# GRANDVIEW RESERVE PHASE 3 PUD DEVELOPMENT PLAN & PRELIMINARY PLAN

PRELIMINARY UTILITY PLANS  
 PRELIMINARY UTILITY PLAN 6 OF 7

# V1\_ Preliminary Utility Plan (1).pdf Markup Summary

COVER SHEET

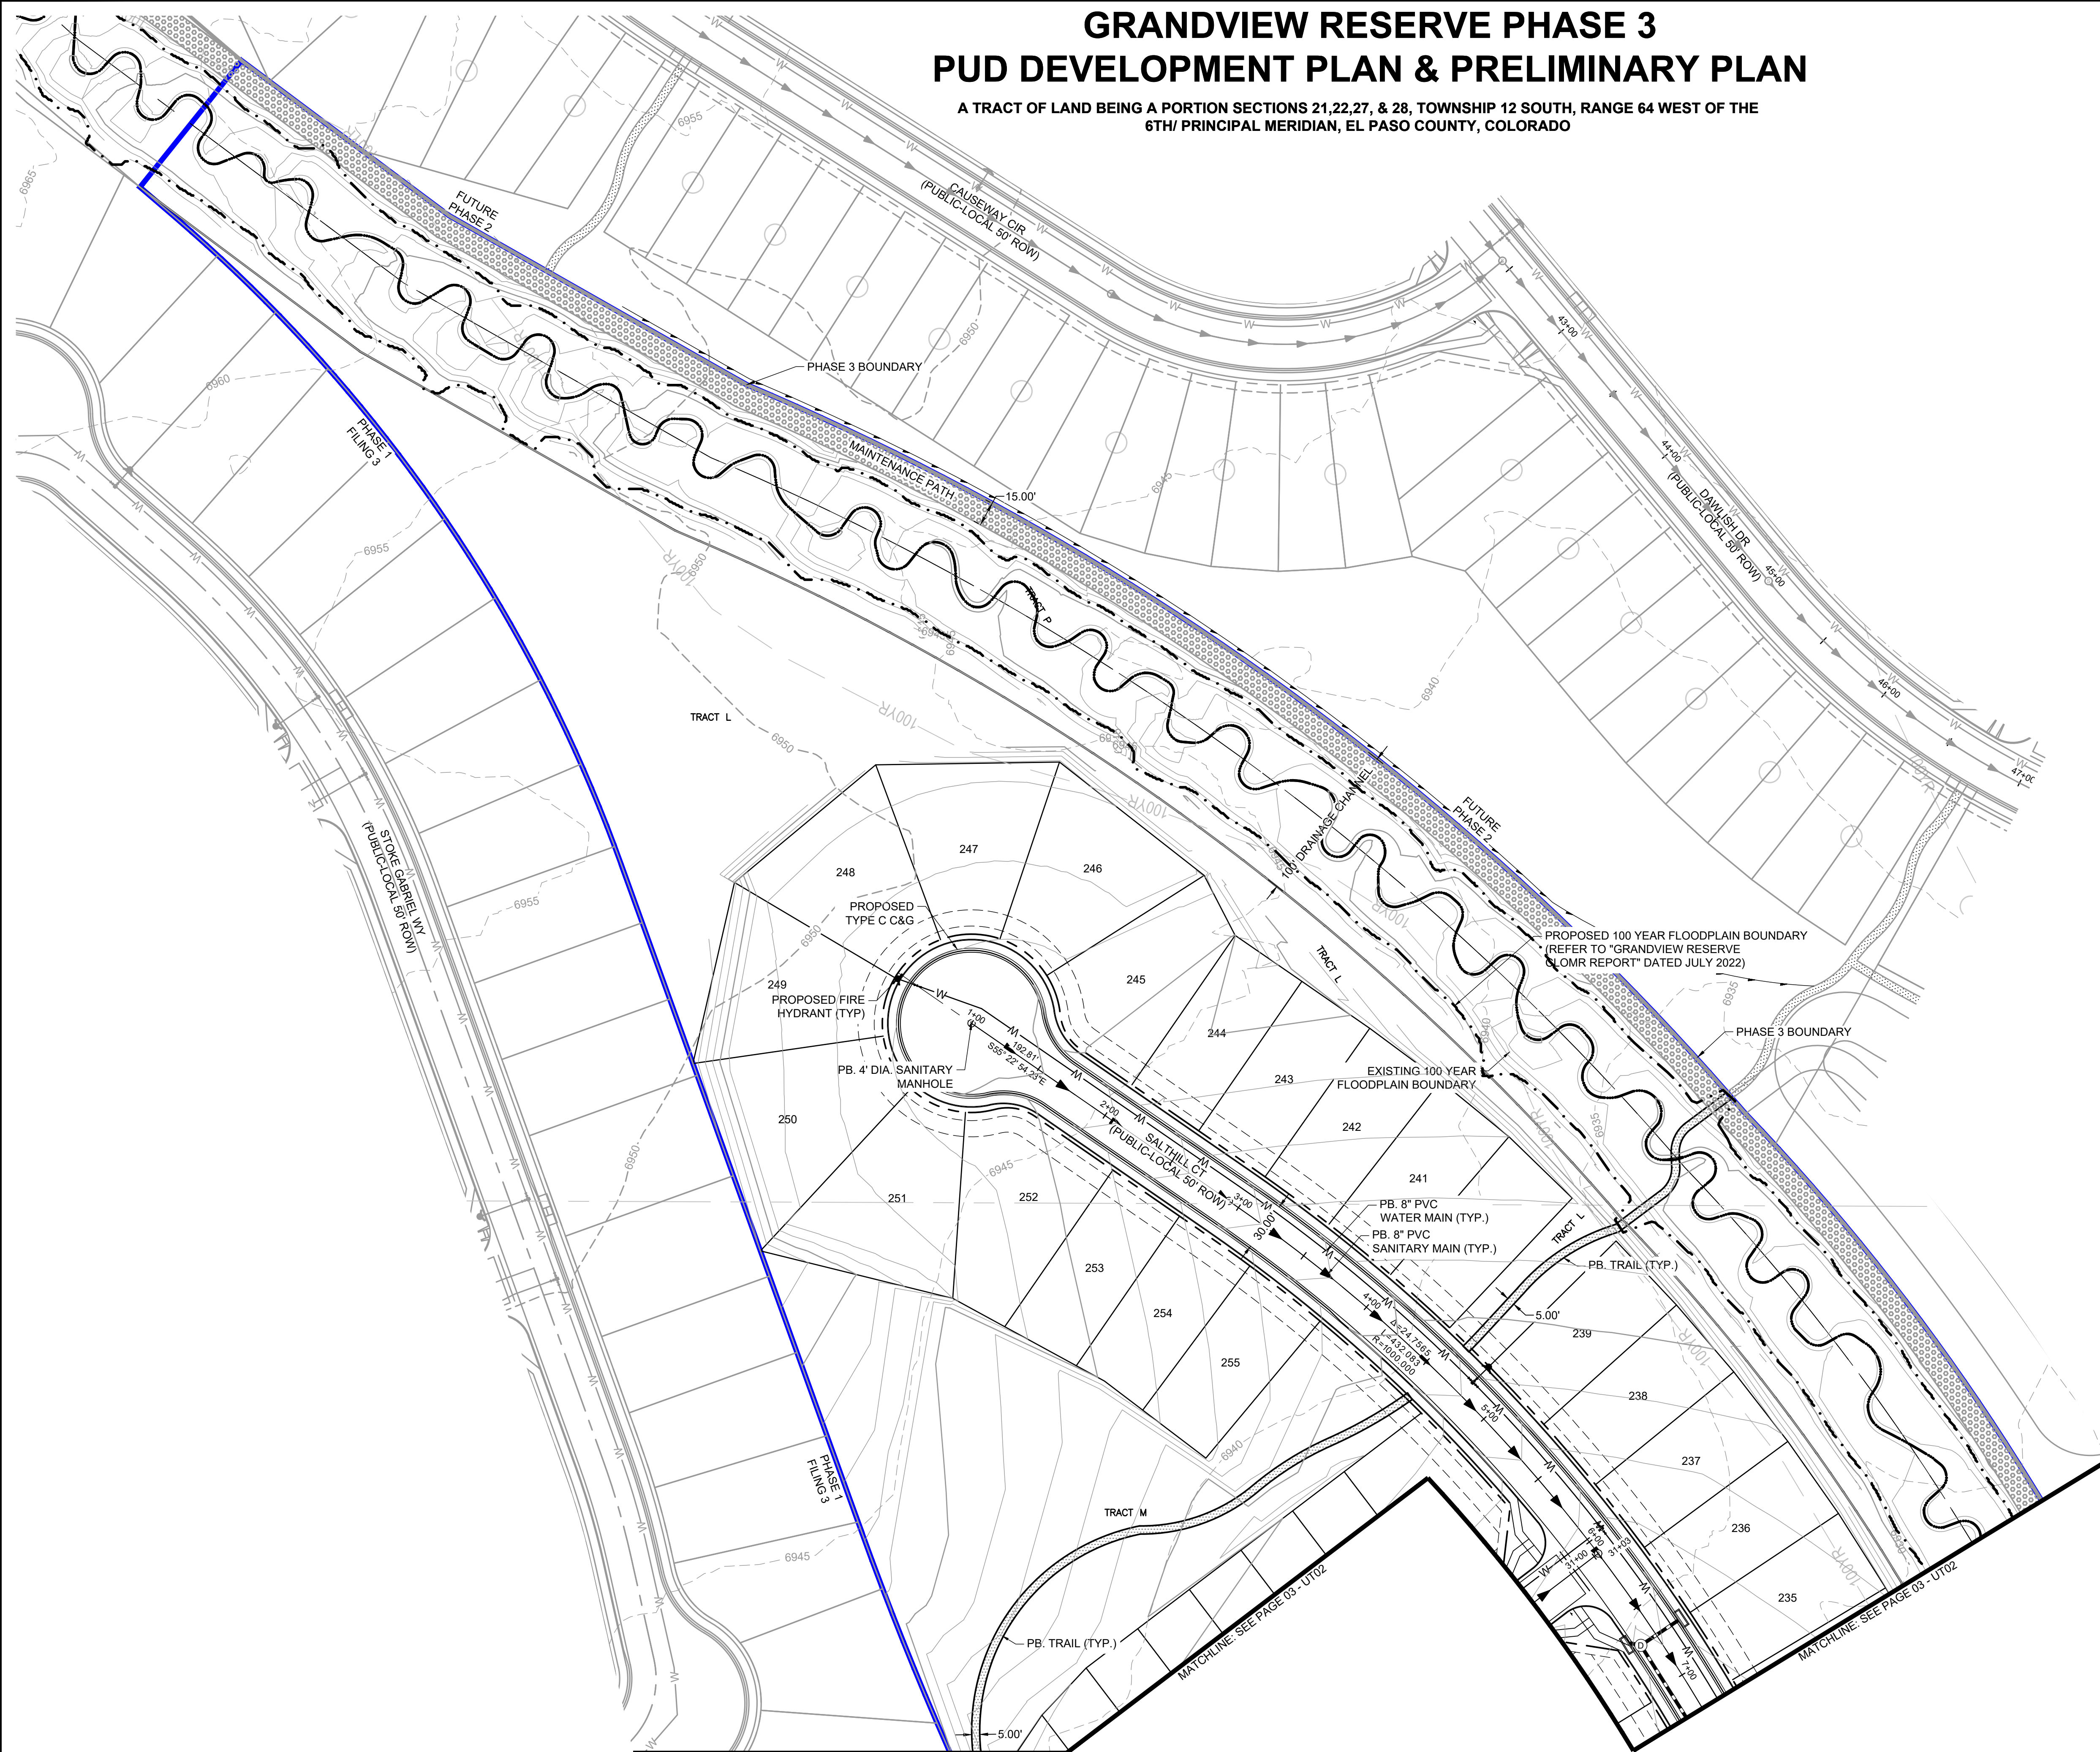
Sidewalks should go behind inlets to ensure ada compliance of sidewalk (typical, all sheets)

Ensure all existing and proposed easements are shown and labeled

Show utility stubs or provide detail showing general location within lot.

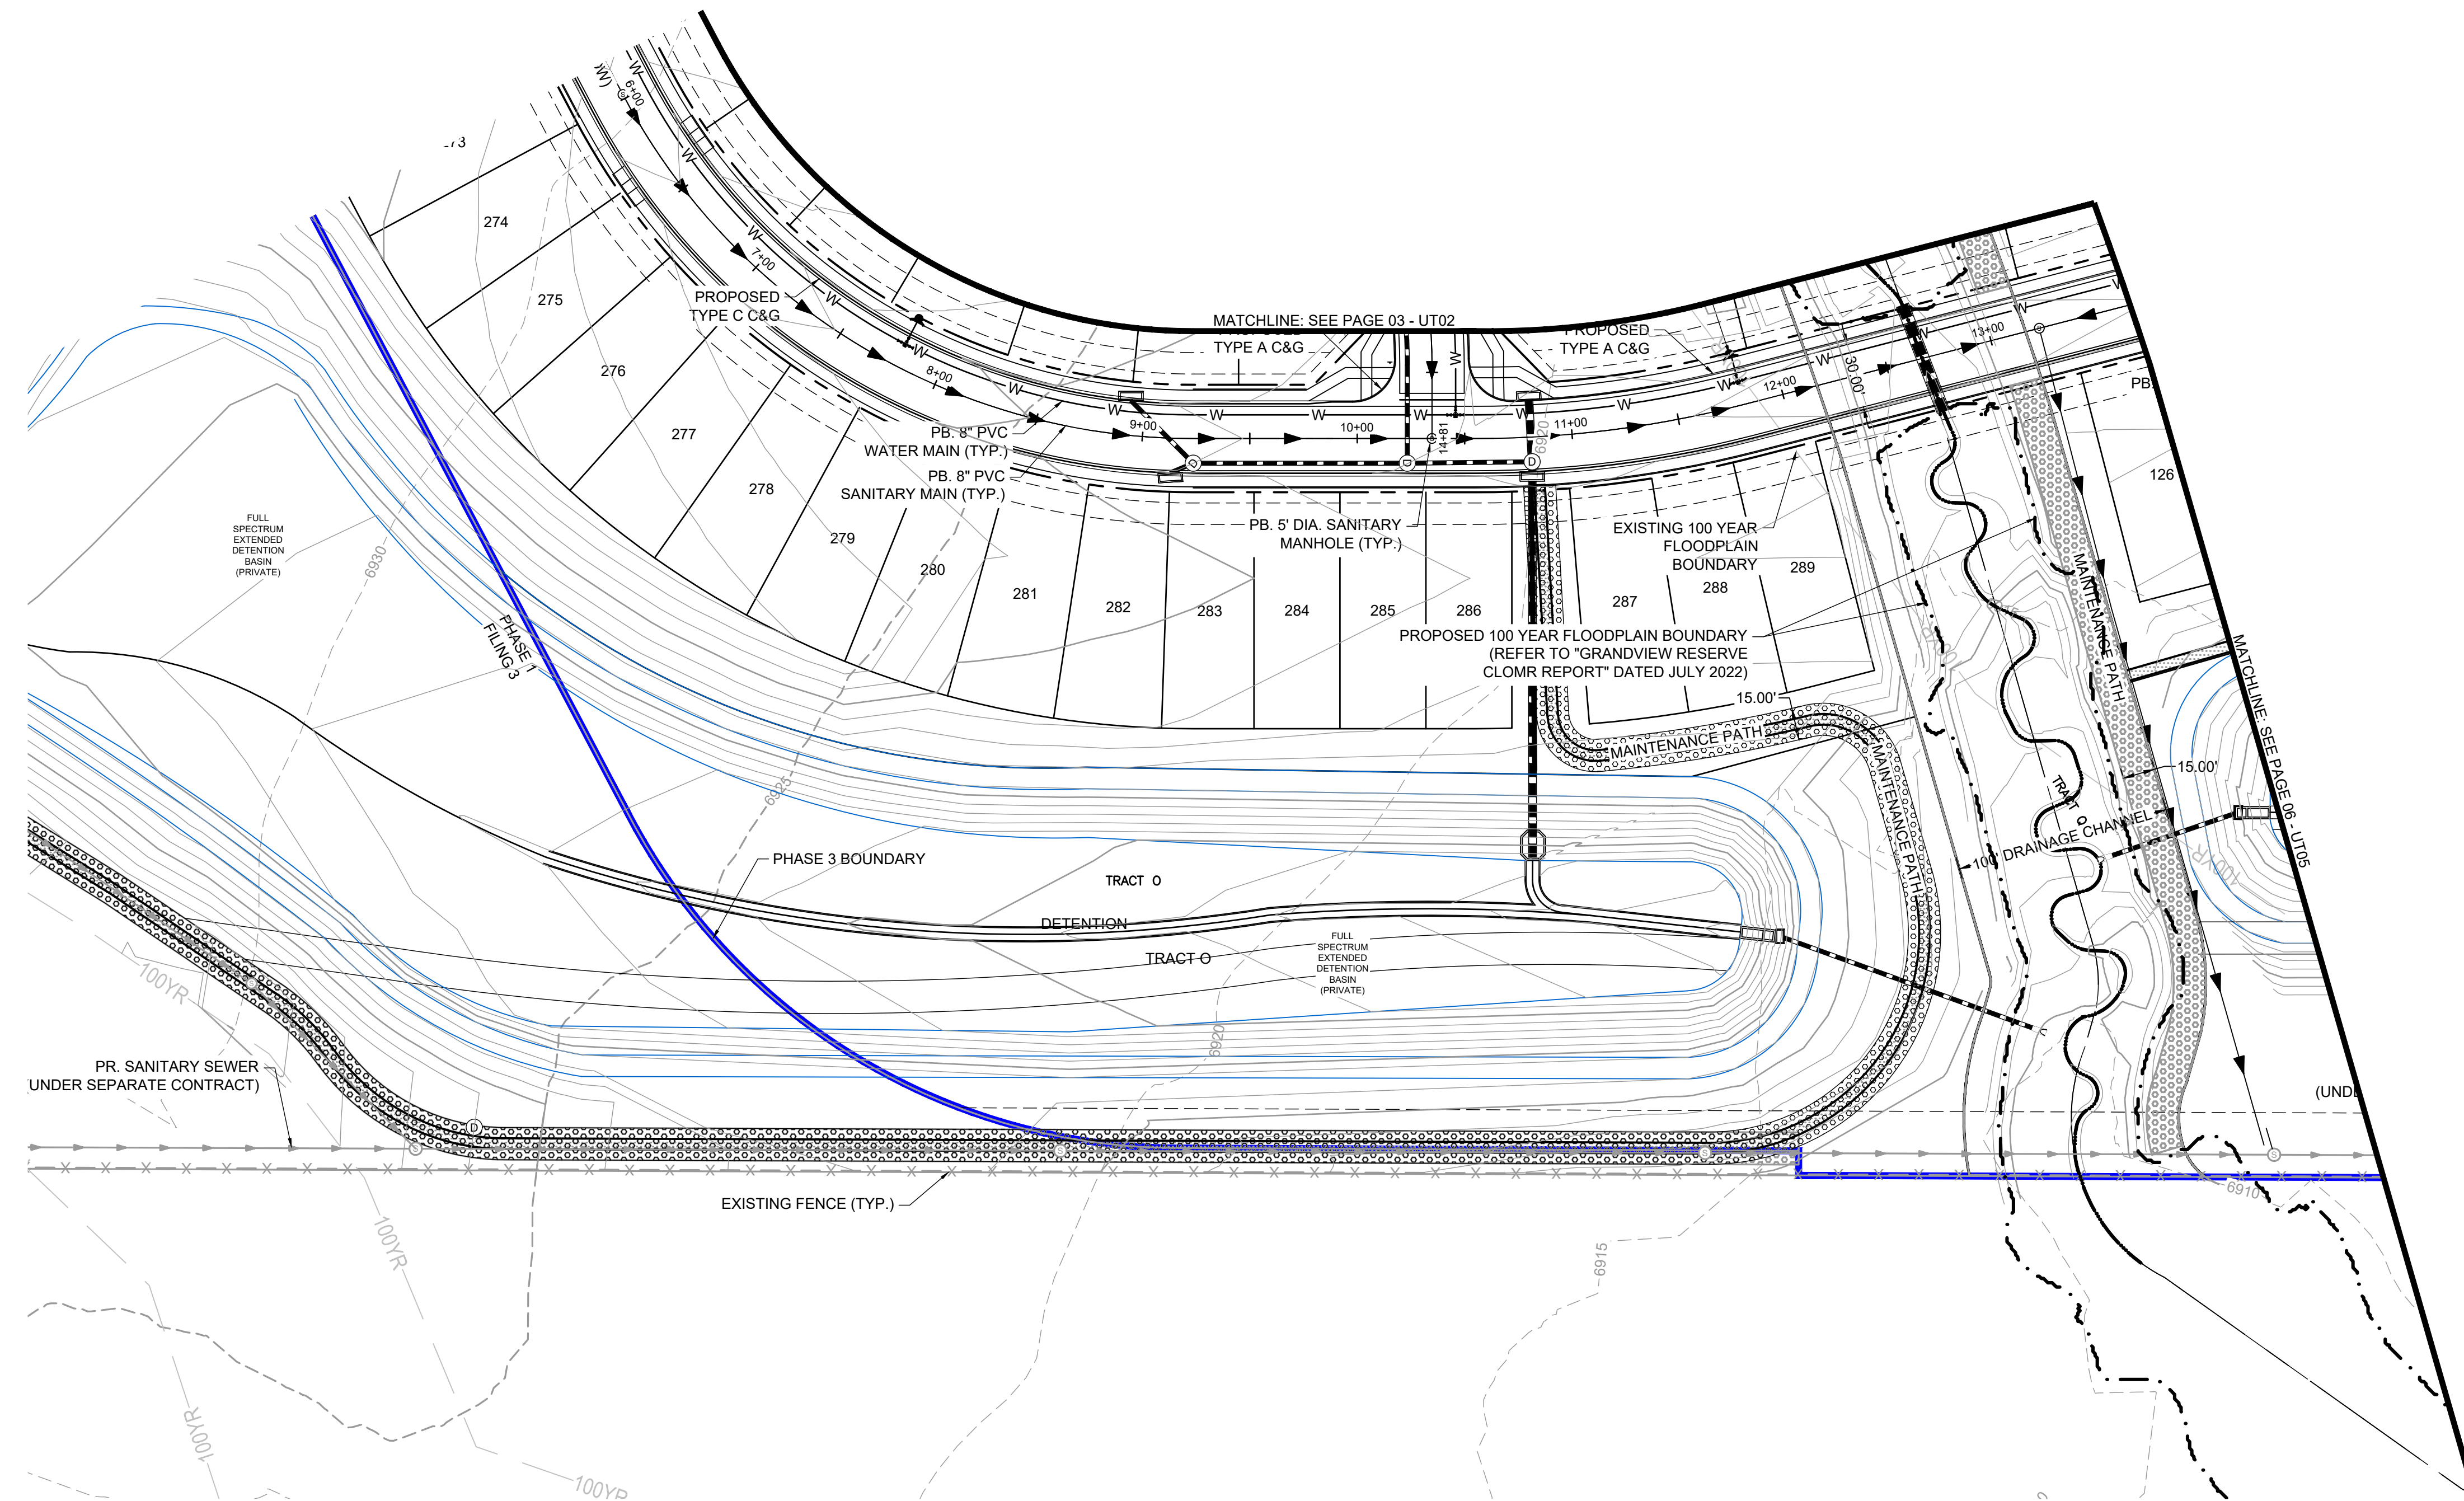
Conflict between inlet & trail

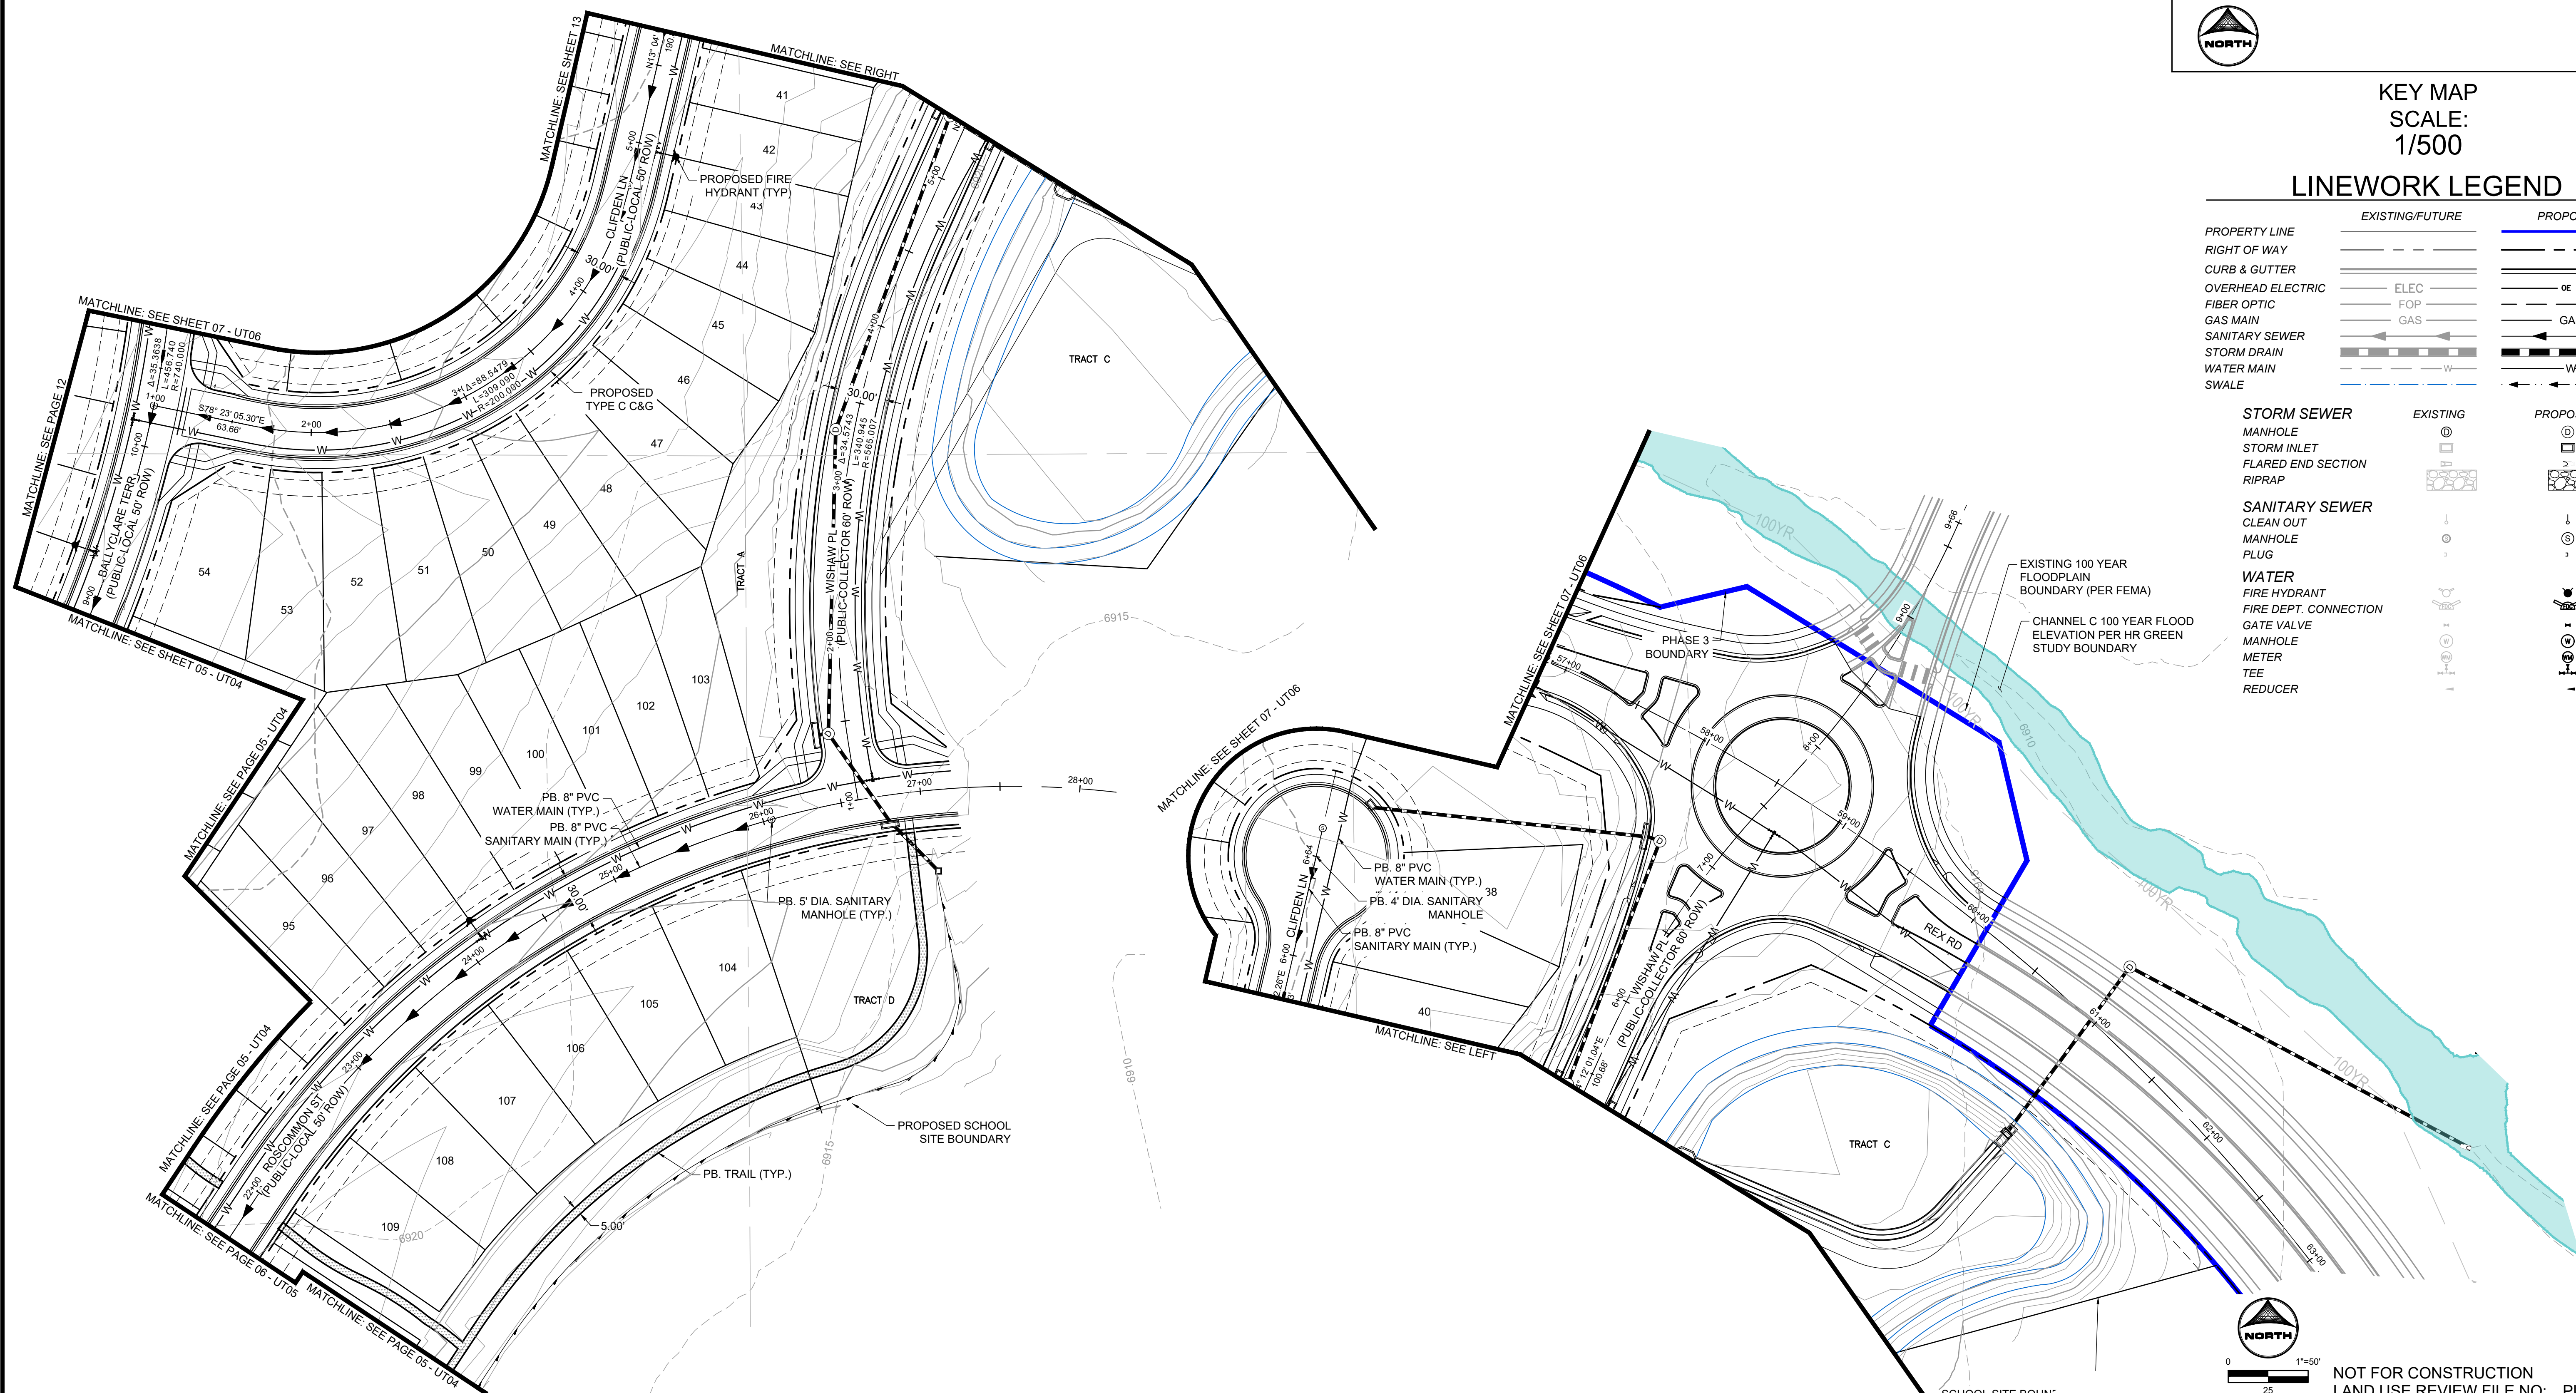
Conflict between ped ramp and inlet
